DECISION DELEGATED TO DEVELOPMENT MANAGER

Application No: H15-0174-19 **Applicant:** Miss P Clare
Proposal: Proposed bungalow - Outline approval H15-0737-18
Location: 76 Main Road Quadring Spalding
Terminal Date: 16th April 2019

South Elevation (1:100)

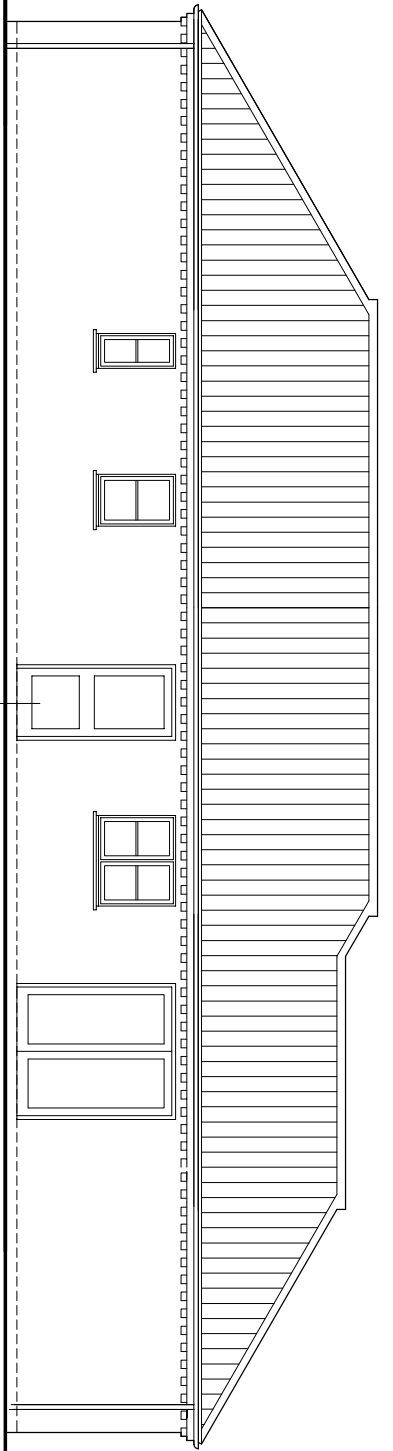
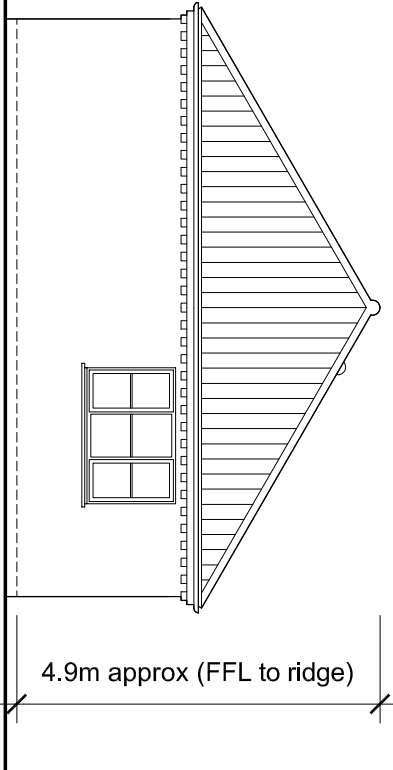
In terms of the design of the bungalow, it would be constructed of red brick and orange pantiles with a hipped roof. Brick detailing would be incorporated at the eaves. This is considered suitable.

Proposed Site Plan (1:200)

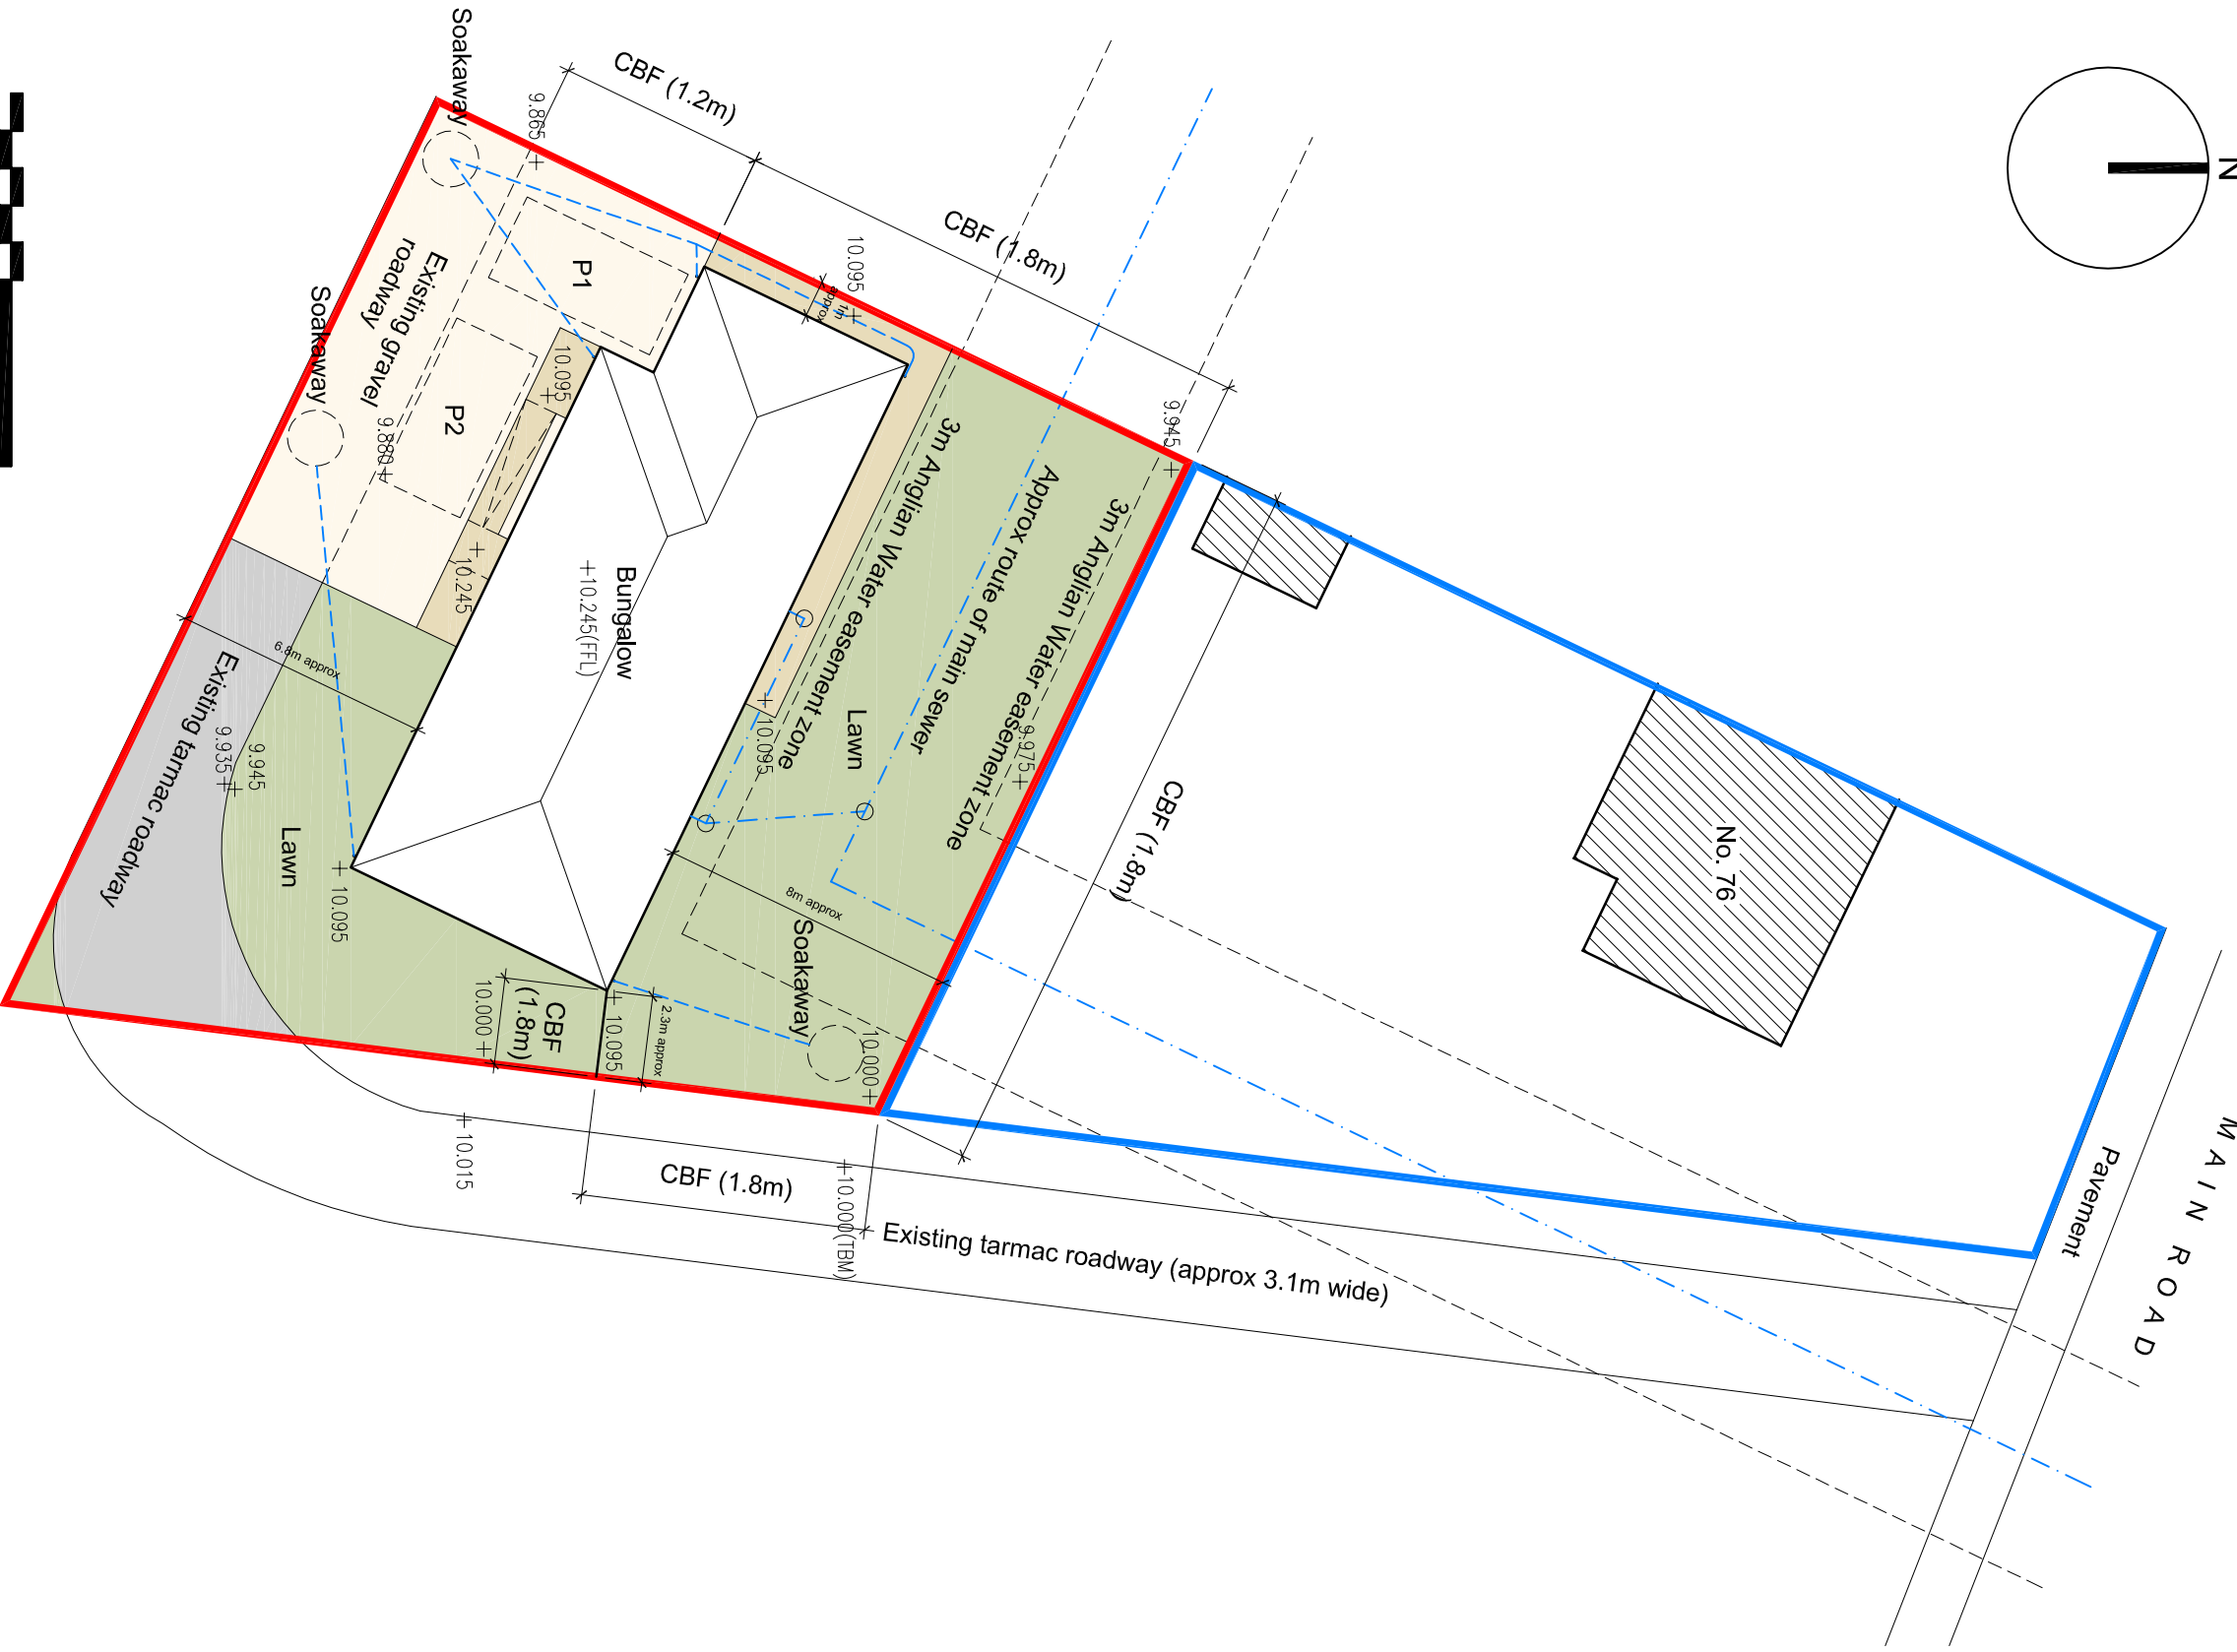
Quadring Parish Council - We think that the garages are too near the roadway and could cause problems. We would also like to point out that the soakaways are situated on a SHDC owned roadway. This proposed property is now much larger than the original plans and will cause problems with the access onto the right of way onto the adjoining roadway, which is partly owned by the SHDC and local residents, who had to pay to have it gravelled. The plans put in originally were deemed to be ok, so why has this now been changed?

- Outline permission was for a 2 bed bungalow now it is for a 3 bed bungalow plus garage
- Size of proposed bungalow is not suitable and not in keeping with frontage properties
- Bungalow with garage and parking is squeezed on to the plot and only 1 metre from neighbouring property
- Access to site is limited via a 3 metre wide road meaning builders will block the access road
- Landscaping of scheme will be limited due to size of plot
- Concern re highway safety and restricted view on corner of road
- Proposed development is out of place on a garden
- Concern re potential for damage to road and responsibility for rectifying this
- Only residents of frontage properties have right of way on the road

Objections have been received regarding the scale of the proposed bungalow, parking provision and it being out-of-keeping with the existing frontage properties. The proposed bungalow is sizeable, however an 8 metre long rear garden would be provided which would be over 19 metres in width. Furthermore the bungalow would be at least 2.5m from the eastern boundary and 4m from the boundary with the roadway. An objector raised the issue that it would be only 1m away from the boundary of the neighbouring property to the west. This is considered to be an acceptable distance and would be enough to allow pedestrian access to/from the rear on this side. Two off road parking spaces would be provided at the front of the dwelling as well as a single attached garage. This is acceptable when taking into account Policy 36: Vehicle and Cycle Parking and Appendix 6 (Parking Standards) of the SELLP. In terms of character, there are existing bungalows to the east which front on to Main Road and so a bungalow is considered appropriate in this location. It would also eliminate any issues of overlooking that would be associated with a two-storey dwelling.

In terms of landscaping, the front, side and rear gardens would be laid to lawn, the driveway would be gravel and pathways would be paving slabs. With regard to the proposed boundary treatment, 1.8m high close boarded fencing would be installed along the western and northern boundaries and part way down the eastern boundary. The remainder of the boundaries would be open. This is acceptable.

The site would be accessed via the existing roadway off Main Road, which also runs to the rear of the frontage properties. LCC Highways have not objected to this. Issues relating to the use of this road to access the proposed dwelling have been raised, however the applicant has confirmed that the road immediately in front of the plot (to the south) is within the applicants ownership and has submitted a Land Registry document in support of this. Any damage caused to the road would be the responsibility of the developer to rectify.

In response to the Parish Council's comments, the agent has highlighted that: "There is only one garage and that this has been specifically designed to allow for a car parking space in front. The front elevation is also stepped back from the main bungalow front elevation. It is not considered, therefore, that the garage is too near the roadway. Indeed further along the row of houses, some properties have garages in a similar location with parking in a similar location. In respect of their second point about ownership. The roadway to the south falls within the applicant's legal ownership." A scan of a Land Registry plan has been submitted to demonstrate this. In response to resident comments, the agent has responded that: "There are numerous examples of recent bungalow planning permissions (both individual sites and housing developments) where the garden surrounding the bungalow is far smaller than this application. I am happy to forward the SHDC planning permission refs if required. The distance of 1m is perfectly normal, and again, I could quote numerous planning permissions where new bungalows have been 1m away (or indeed closer) from new and existing property boundaries. The statement regarding builders vehicles is an assumption. There is adequate space for contractor vehicle parking. The access arrangements for builders are not a unique one. The statement about the new property having no access right is incorrect. The applicant has enquired with their solicitor and there is no stipulation that access is just for no. 76 dwelling. There is, therefore, no legal reason why an additional plot cannot have access rights. The comment about appearance is a personal opinion. By its very nature a bungalow will not look like a house. Their final points about landscaping, scale and parking, I would refer back to my earlier point. Compared with numerous bungalow developments across South Holland, this proposal offers average to above average garden space around the dwelling. The parking is integrated in a way that offers two parking spaces."
